Comments on Routes and Access Points

Green Hill A

Title:
Figure 13.21: AIL Routes to Solar and BESS Sites (Sites: Green Hill A, B, C, E)

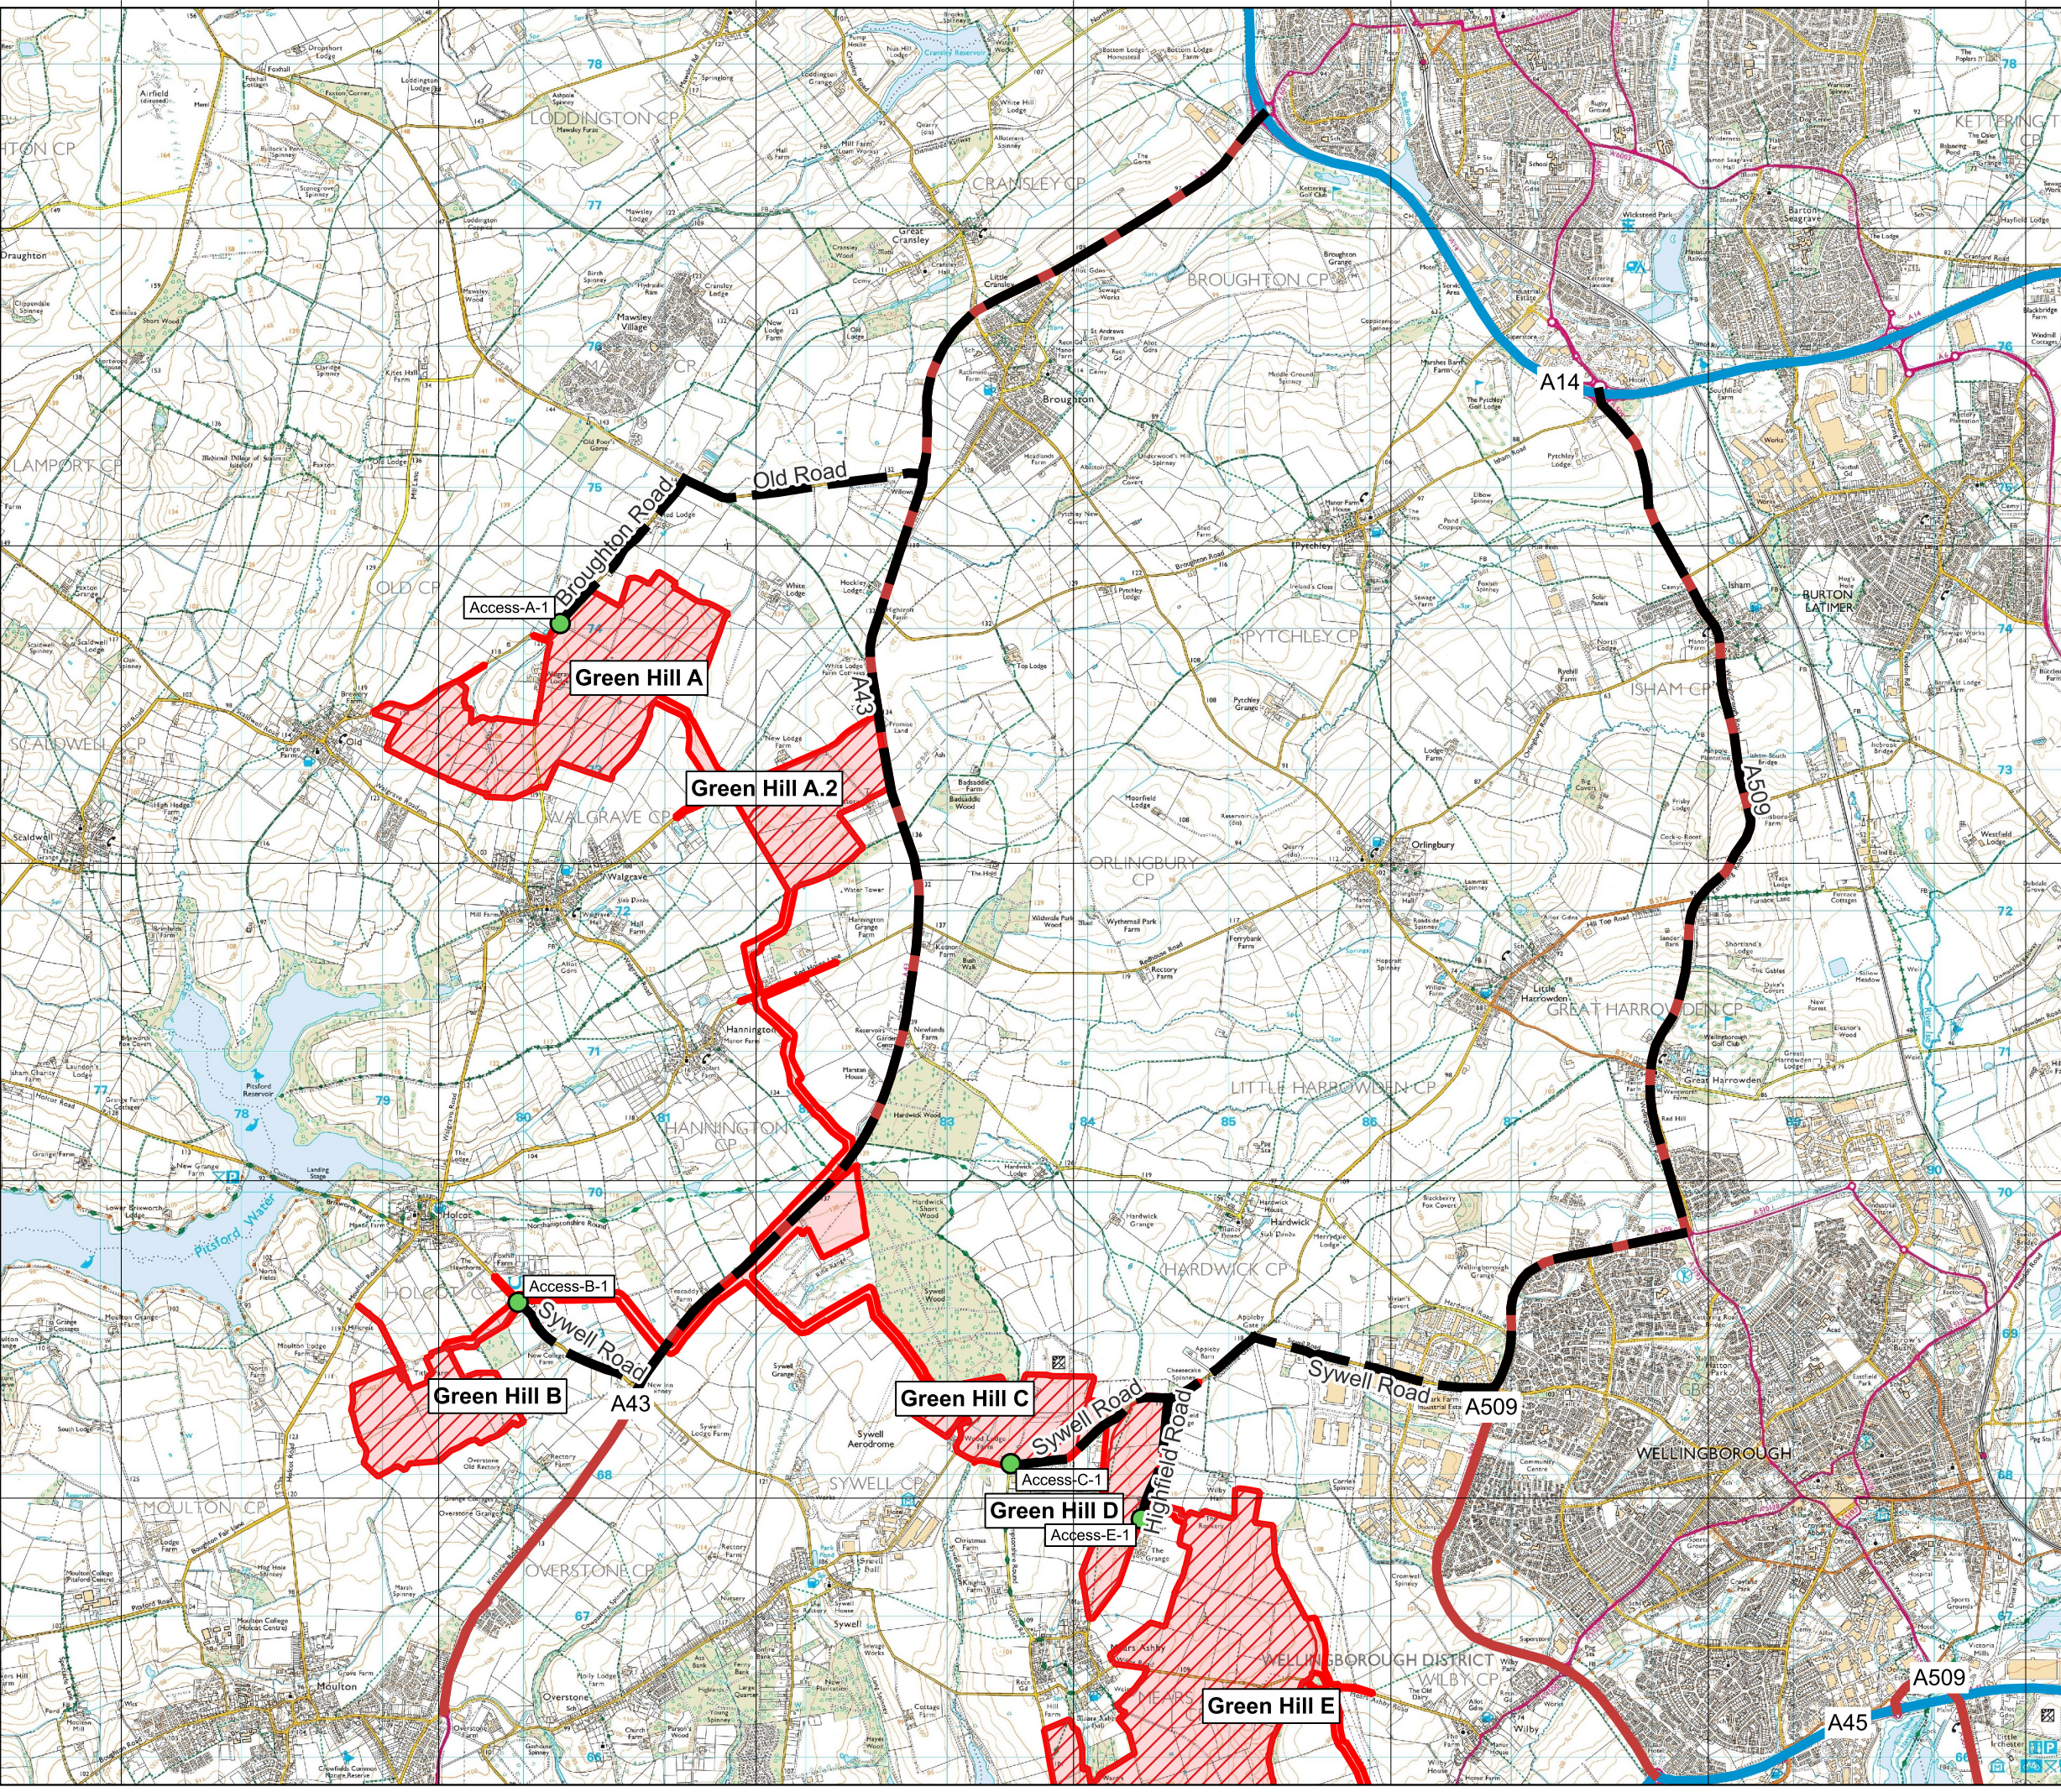
Access C1. This effectively creates a cross roads at an existing T junction that is very well used as an access to the popular Beckworth Emporium shop and garden centre. It is also a very popular 'rat-run' for commuter traffic wishing to access the A4500 and the A45.

It should be noted that the approach to this junction from the west is on a significant uphill gradient within the national speed limit. The curvature and topography of the road severely reduces forward visibility from that direction and correspondingly the stopping sight distance from 60 mph is unlikely to be available.

I consider that the current speed limit and uncontrolled nature of that junction would lead to an unreasonable increase in the likelihood of a road traffic collision and that suitable measures to regulate this junction will be required.

Title:
Figure 13.22: AIL Routes to Solar and BESS Sites (Sites: Green Hill BESS, F, G)

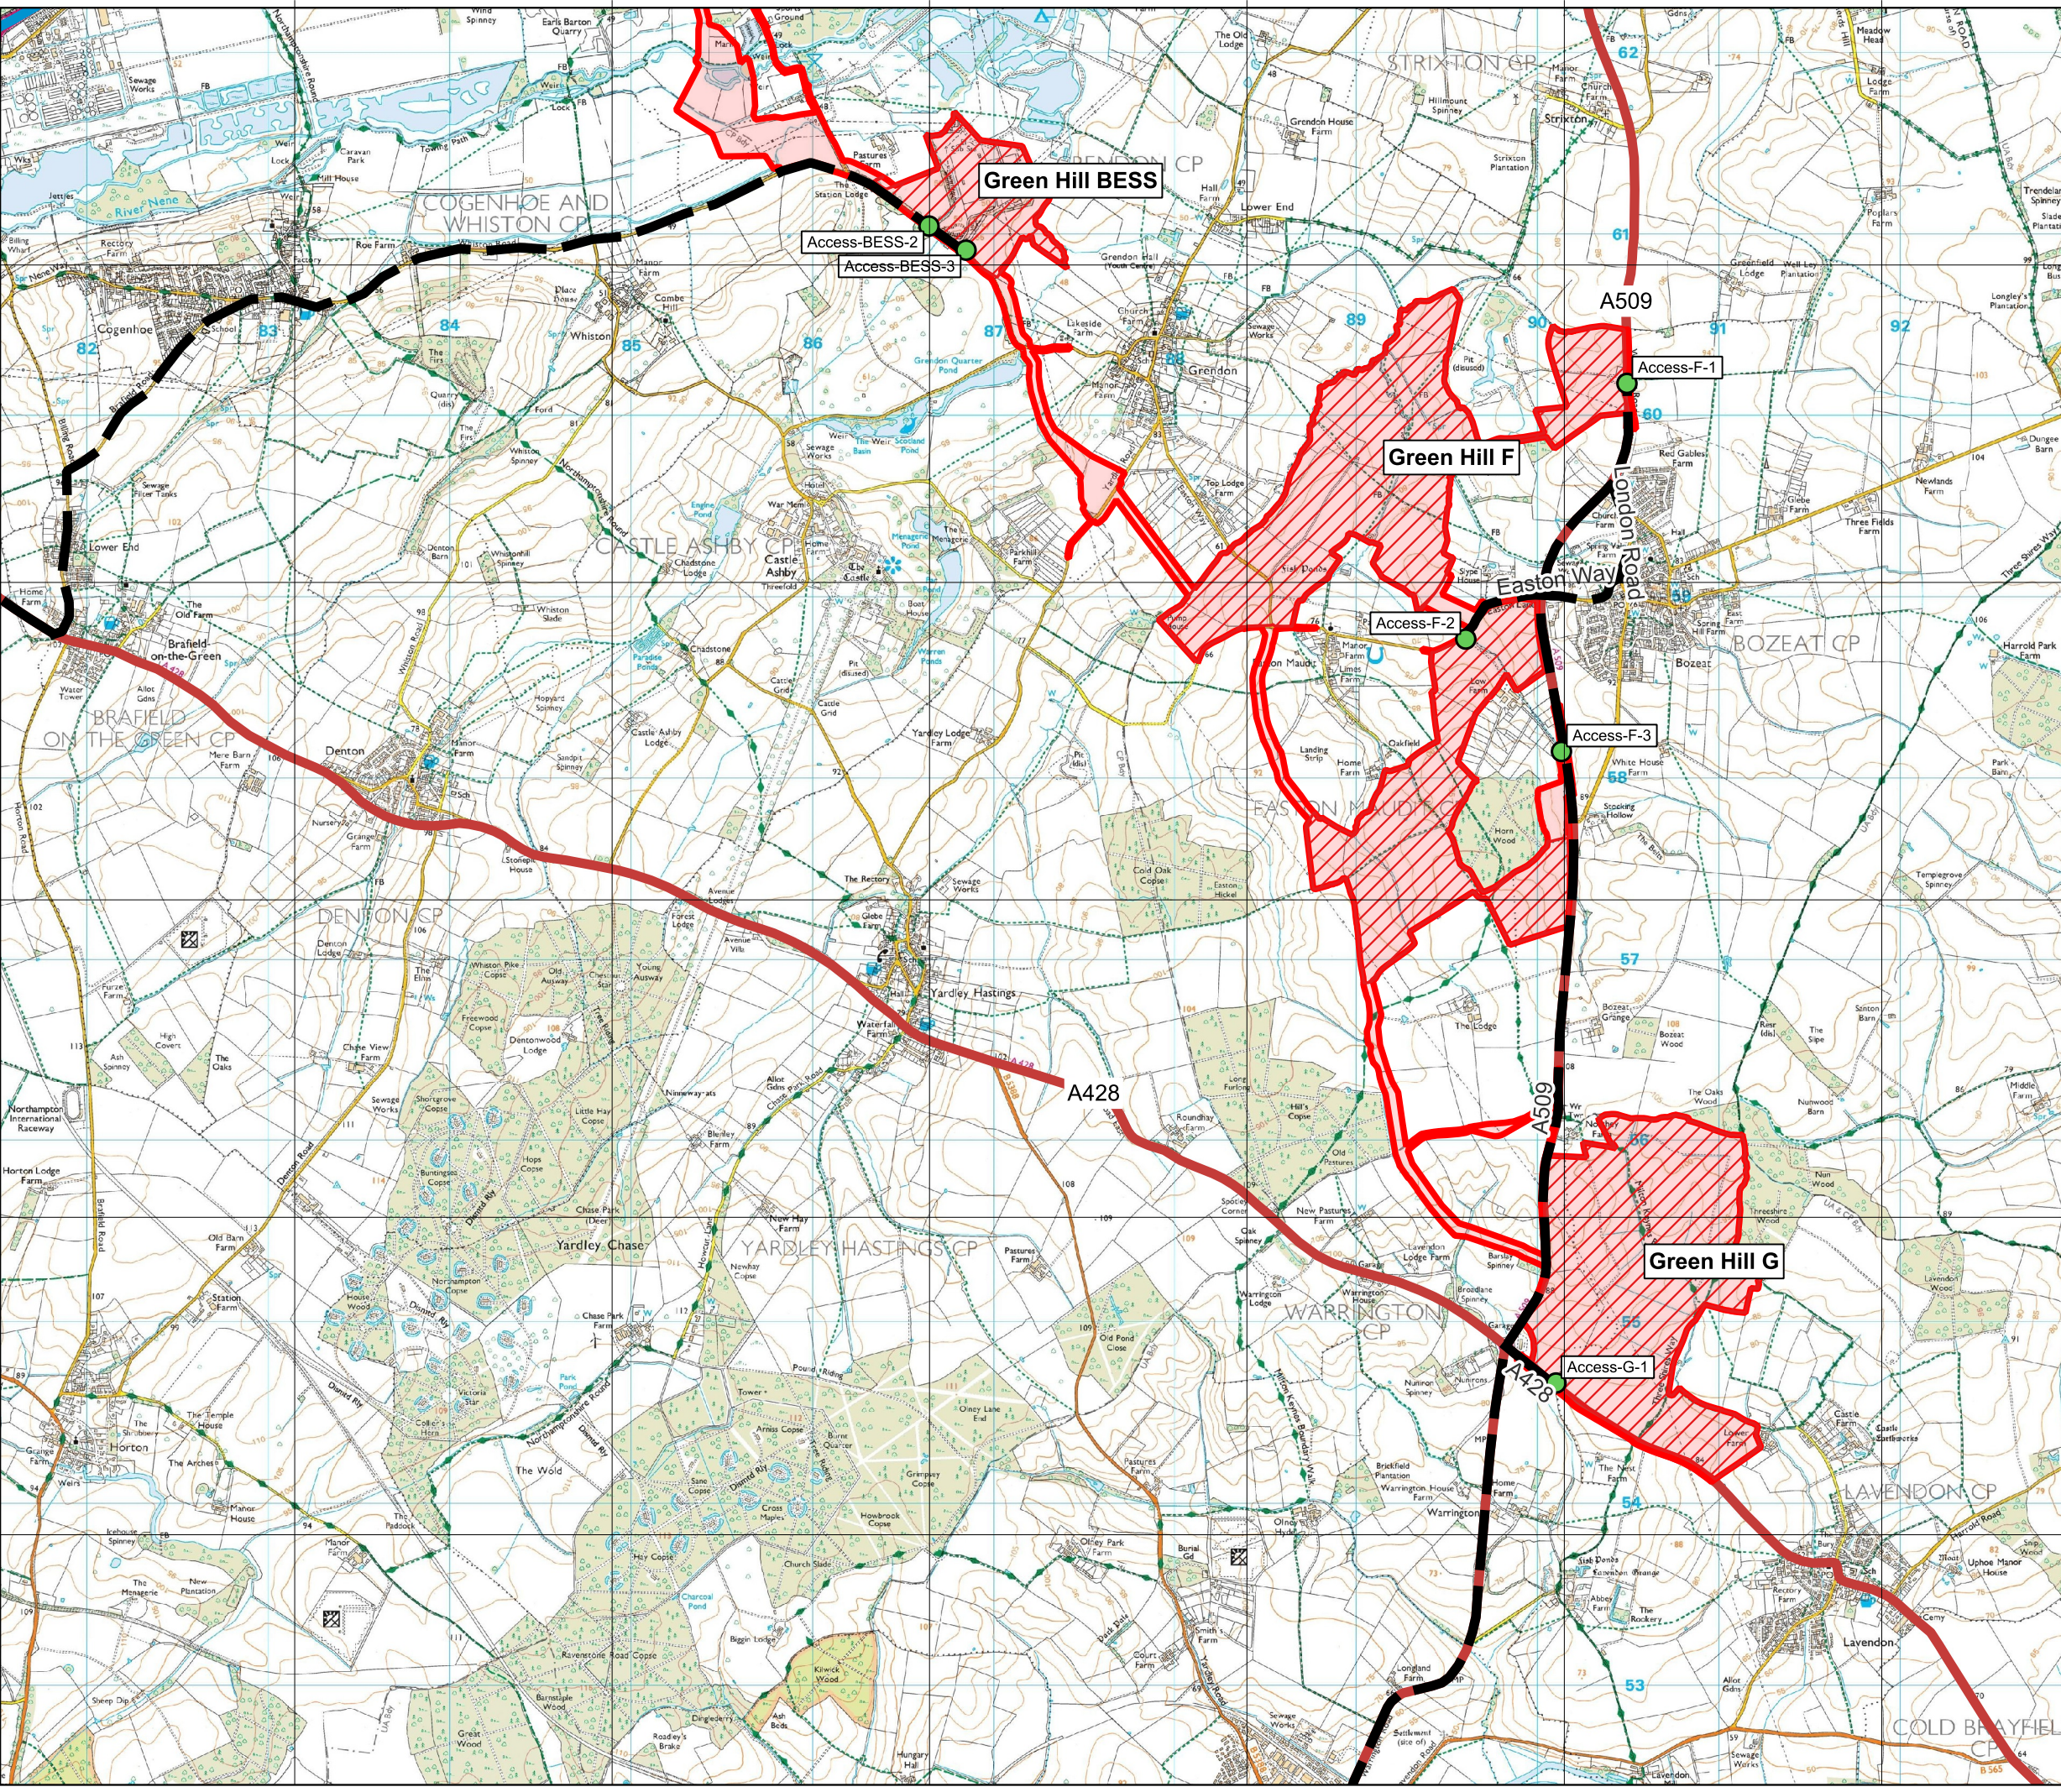
I have also looked at the exceptional load route that will come through Brafield and Cogenhoe. On that I would comment as follows.

Having exited Brafield and made the right turn towards Cogenhoe the vehicle will have to cross two sets of low hanging local electricity supply cables that may well be lower than the overall height of the load. Having reached the centre of Cogenhoe at the Station Rd junction the auto-track shows the load passing to the right of the central island. Whilst there is sufficient width to do this there is also the presence of a kerbed section that will need to be overridden to make the turn. It is anticipated the some protection and other civil engineering works will be required to make this possible.

Once onto Station Road/Whiston Road there is a steep and windy downhill section exiting Cogenhoe with a lot of overhanging mature trees. It would not be acceptable to cause any undue damage to these trees
